CITY OF ALBUQUERQUE

February 13, 2014

**Re: 7503 Oakland Ave., Jasmine Subdivision
Grading and Drainage Plan
Engineer's Stamp Date 12-23-13 (C19D060)**

7503 OAKLAND
BEING A REPLAT OF LOT 20, BLOCK 3, UNIT 2, TRACT 3, NAA
GRADING & DRAINAGE PLAN

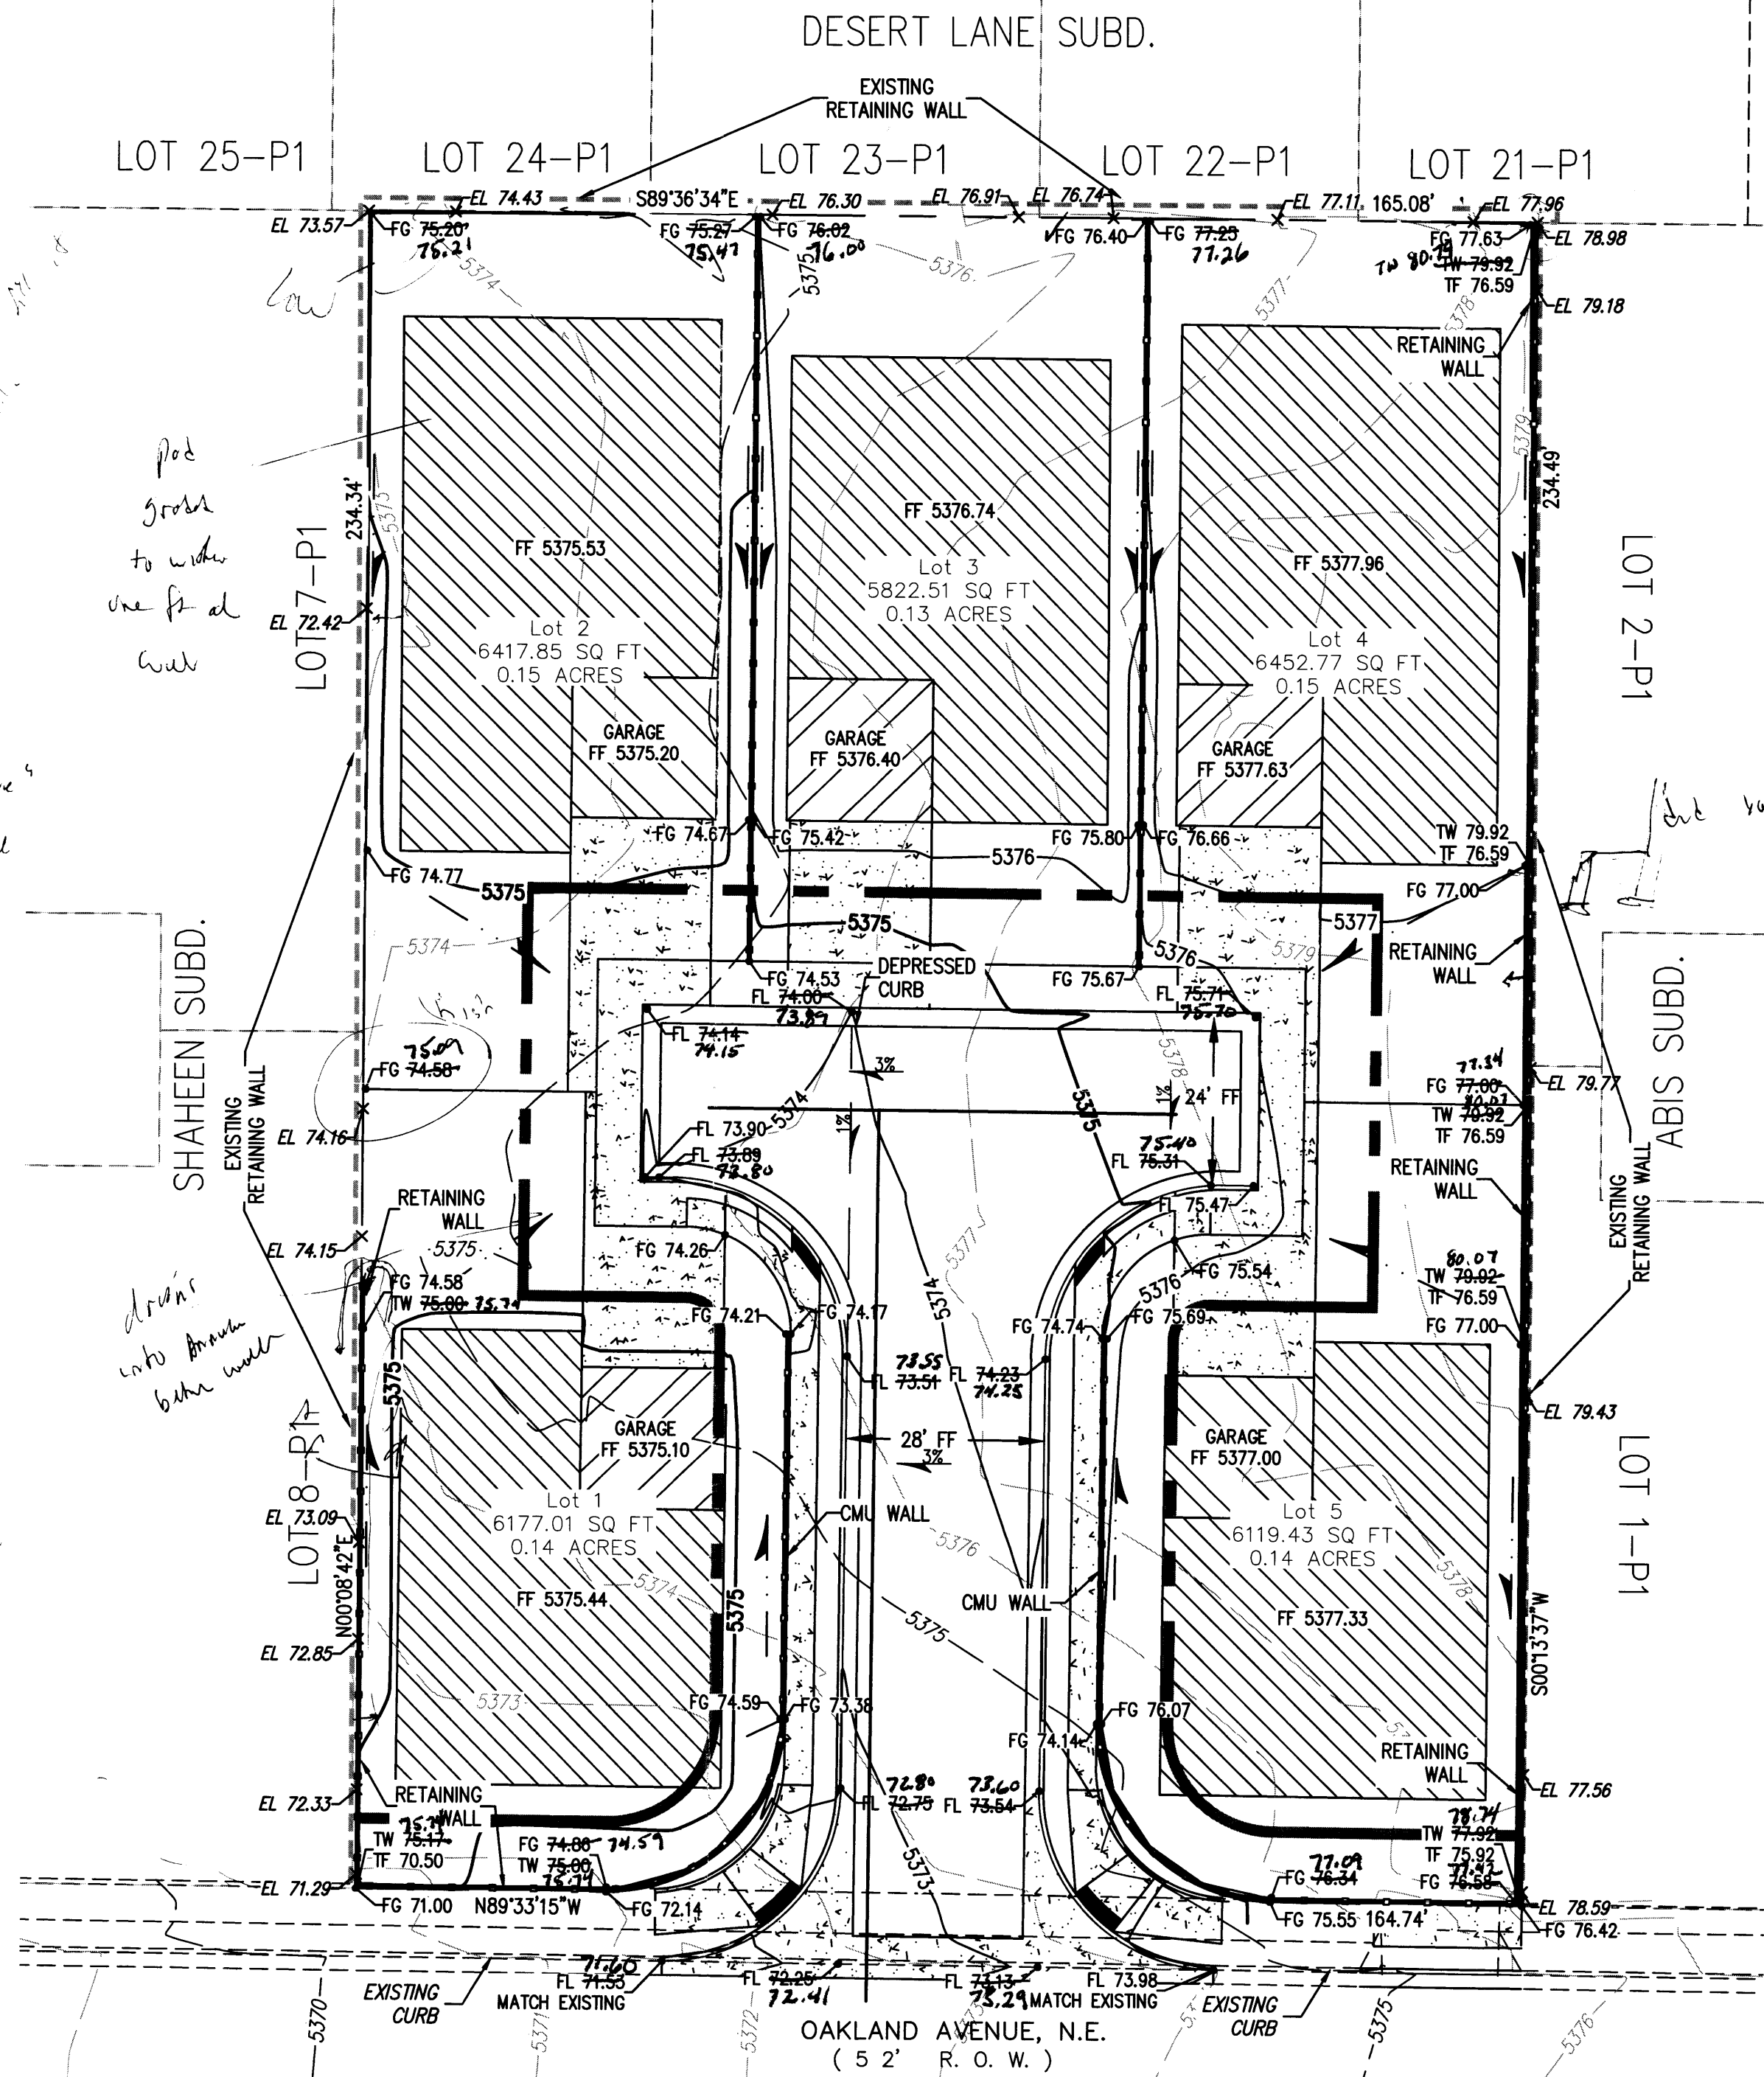
1. Include a statement that the existing retaining wall(s) are acceptable for the additional fill proposed on the engineer's certification or if the wall(s) are found to be unacceptable a revised plan will have to be submitted in order for Hydrology to approve the retaining wall permit.
2. Prior to Work Order or Final Plat approval a revised grading plan is to be submitted and approved showing the sidewalk on the west side of the street and addressing comment number 1.
